# **EL PASO COUNTY PLANNING AND COMMUNITY DEVELOPMENT DEPARTMENT**

## **STORMWATER MANAGEMENT PLAN CHECKLIST ROLLING HILLS RANCH FILING 2**

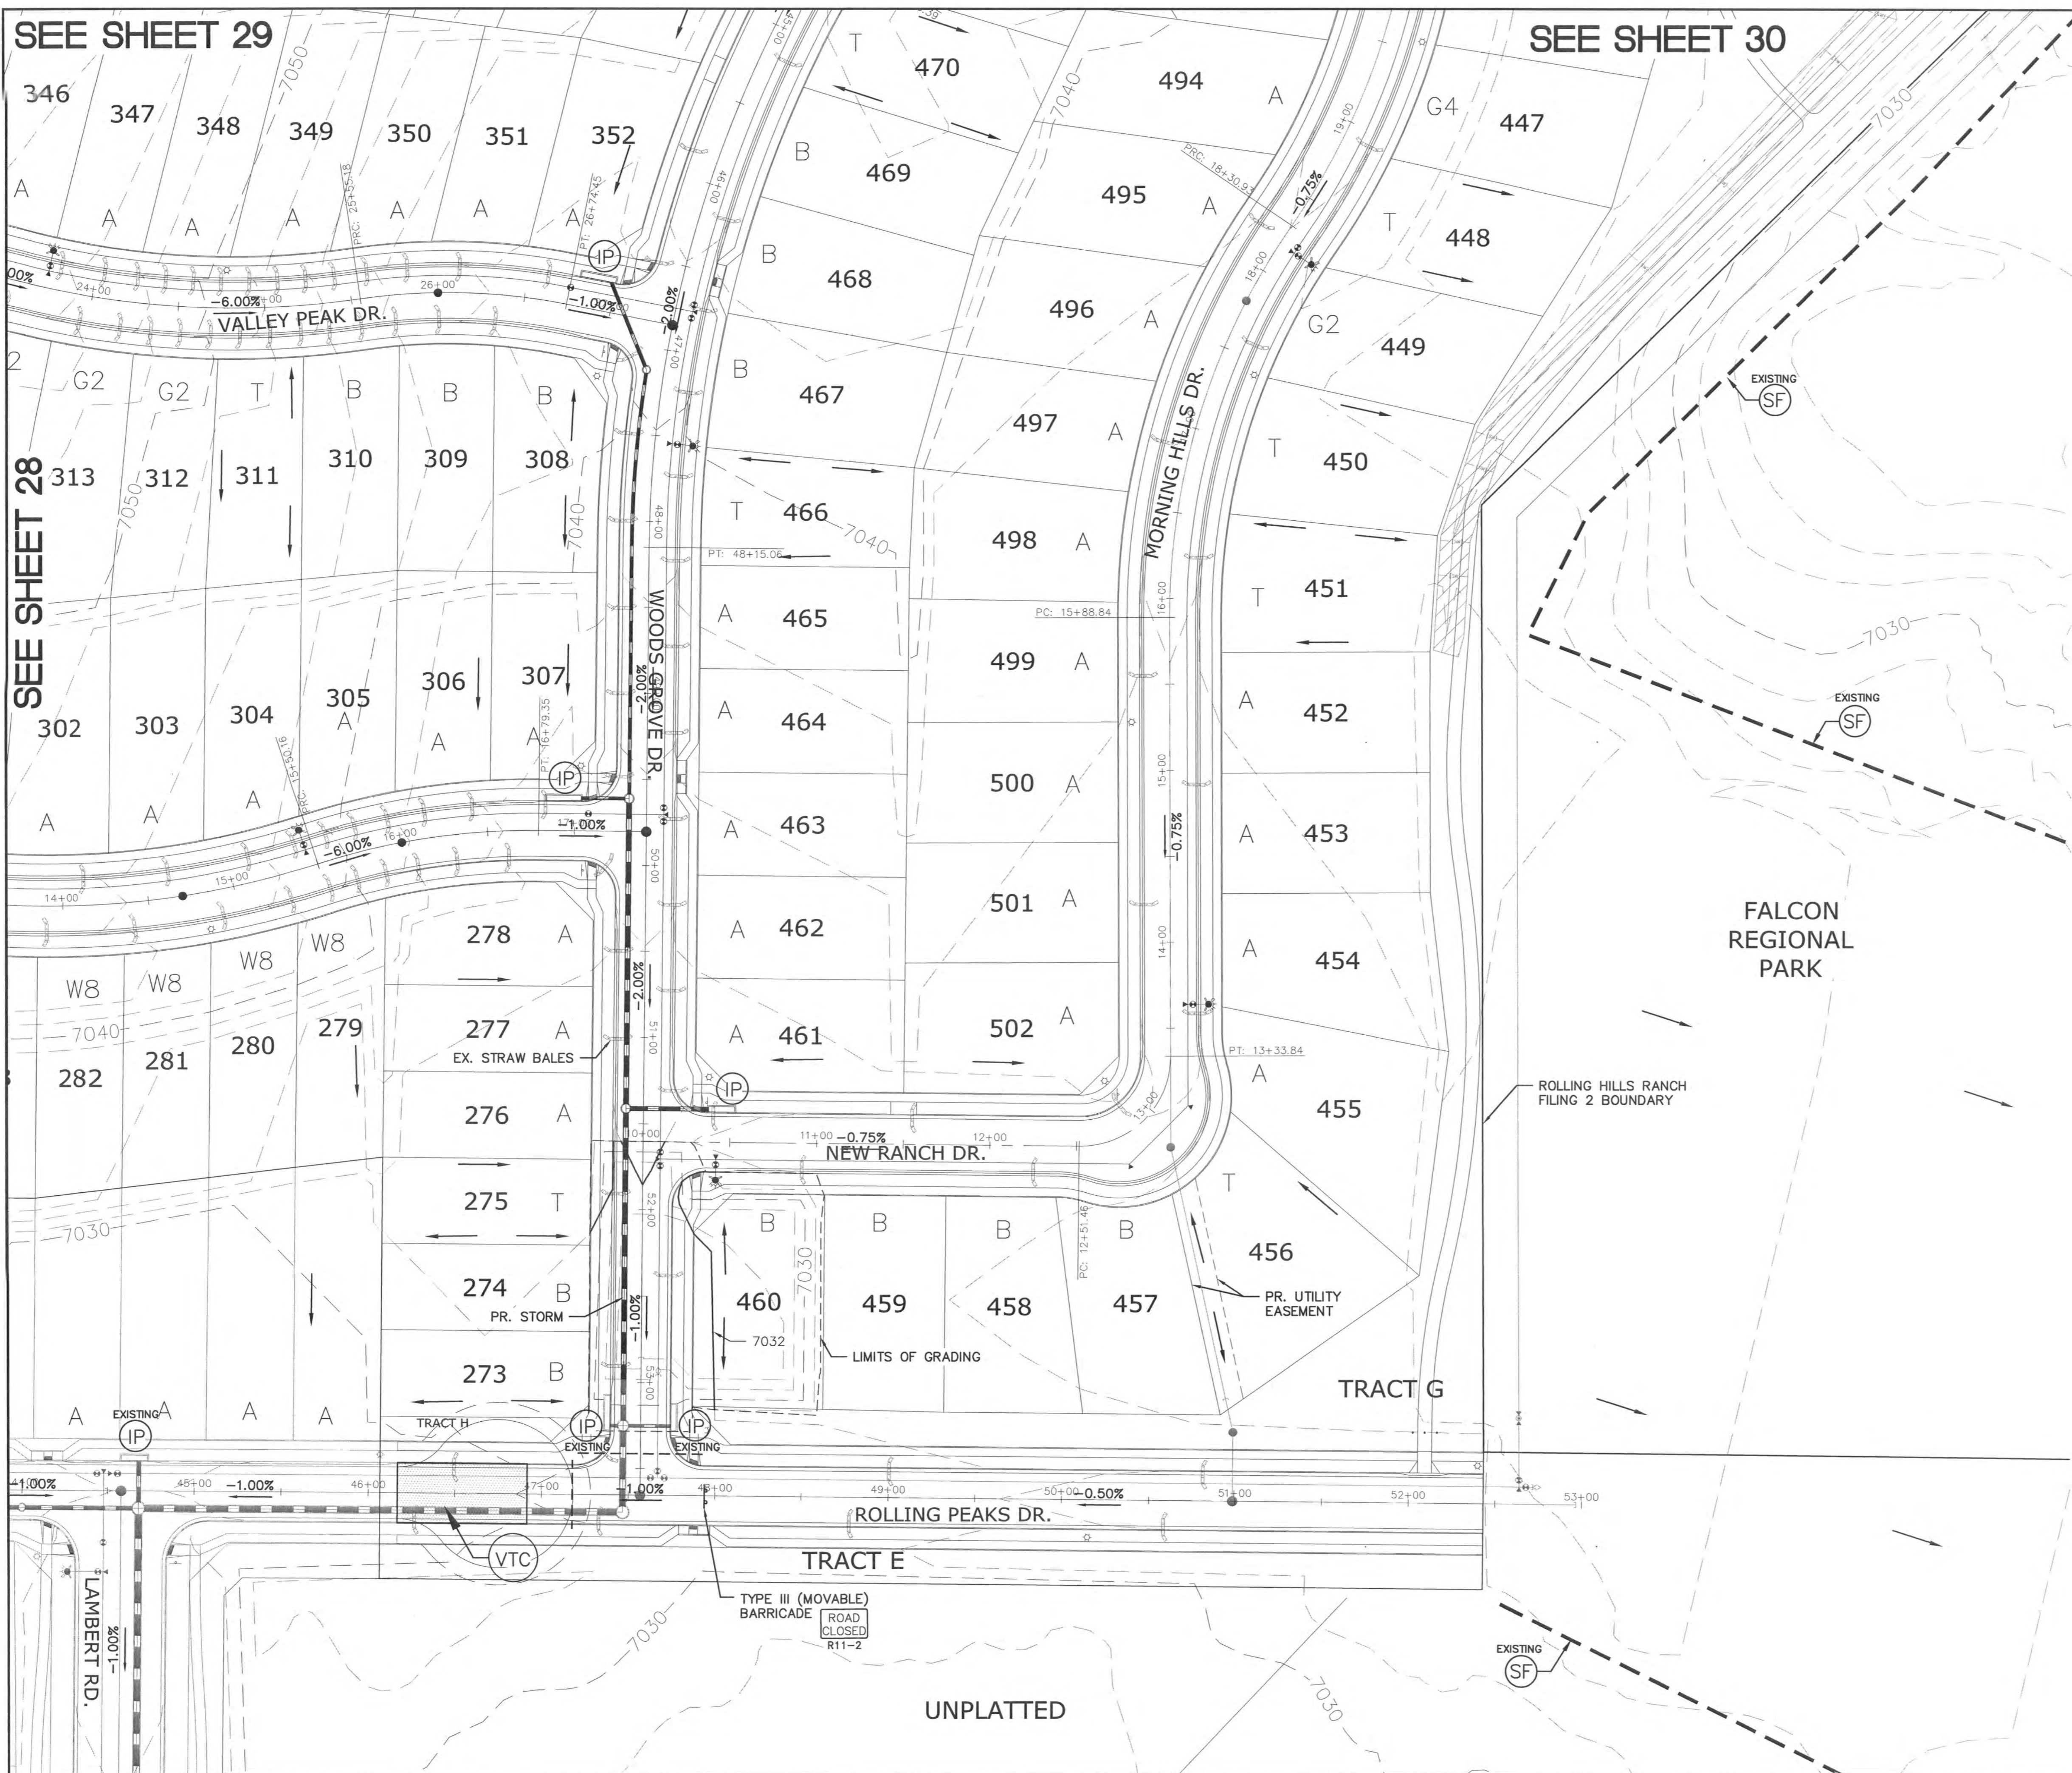
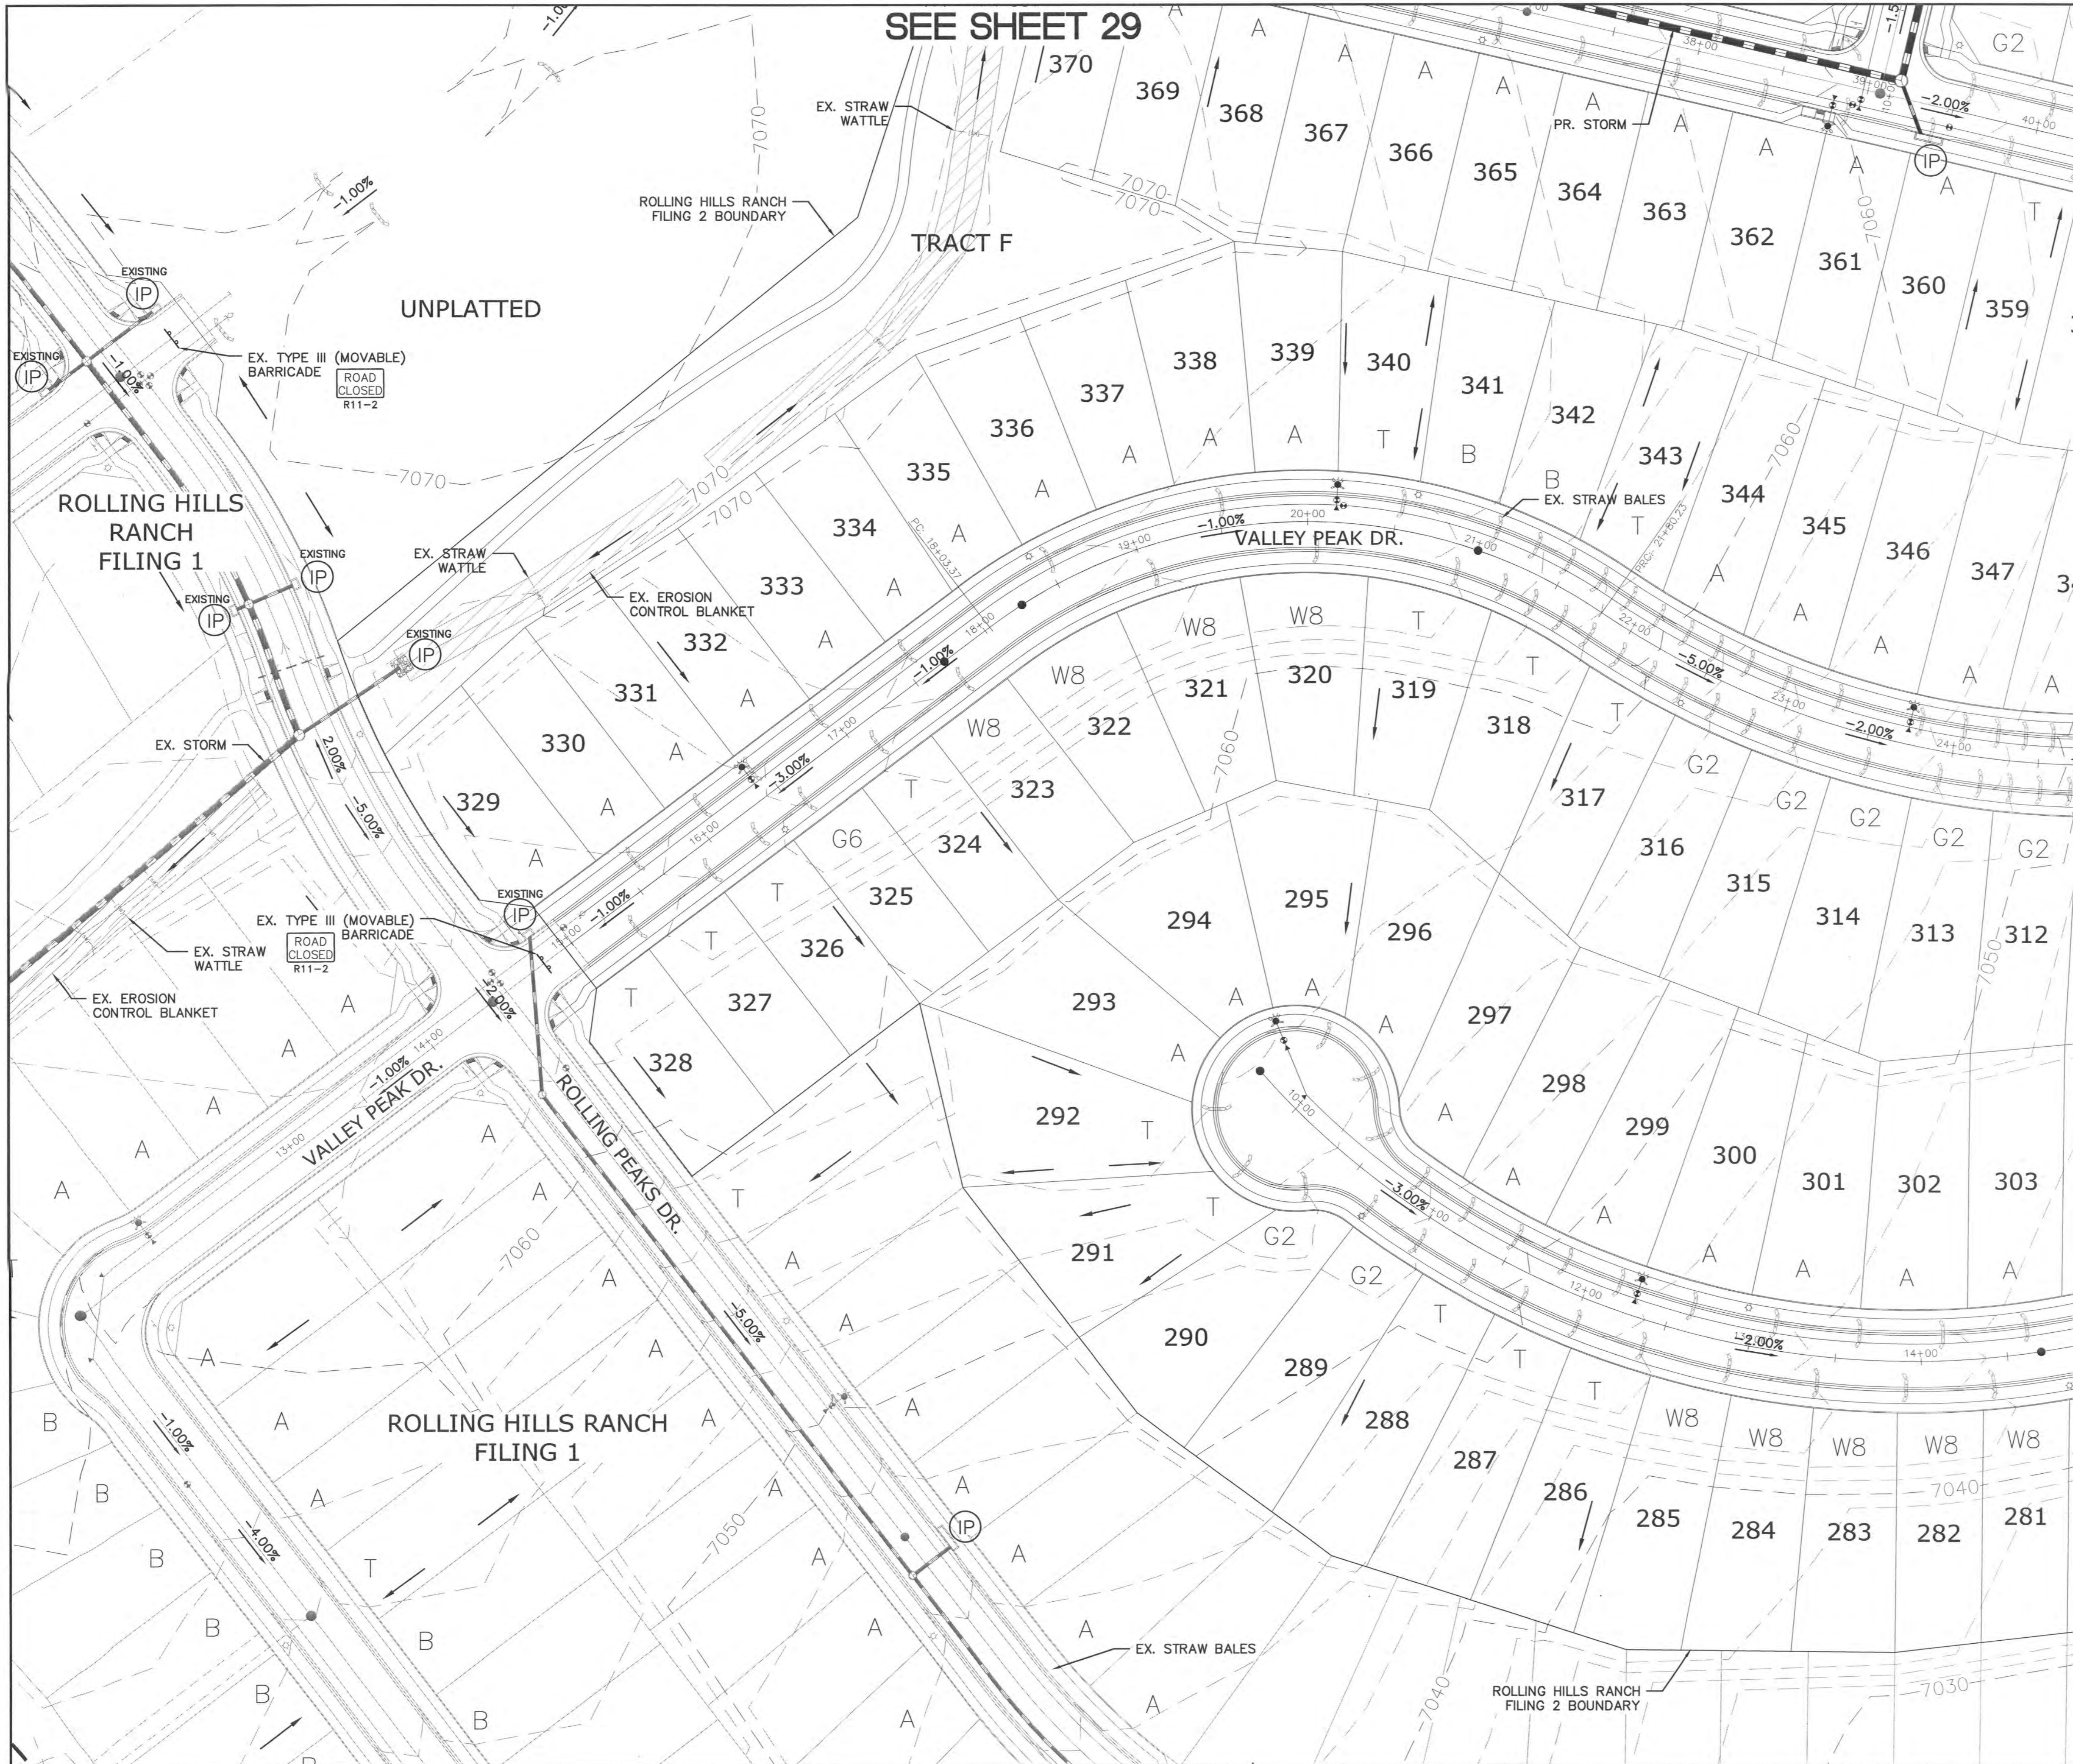
Applicant	PCD
17	SWMP Map to include:		
17a	construction site boundaries	X	✓
17b	flow arrows to depict stormwater flow directions <b>Added to sheets 27-31</b>	X	X
17c	all areas of disturbance	X	✓
17d	areas of cut and fill	X	✓
17e	areas used for storage of building materials, soils (stockpiles) or wastes	X	✓
17f	location of any dedicated asphalt / concrete batch plants <b>Note added to sheet 26</b>	X	X
17g	location of all structural control measures	X	✓
17h	location of all non-structural control measures	X	X
17i	springs, streams, wetlands and other surface waters, including areas that require maintenance of pre-existing vegetation within 50 feet of a receiving water	X	✓
18	Narrative description of all structural control measures to be used. Modifications to EPC standard control measures must meet or exceed County-approved details.	X	✓
19	Description of all non-structural control measures to be used including seeding, mulching, protection of existing vegetation, site watering, sod placement, etc.	X	✓
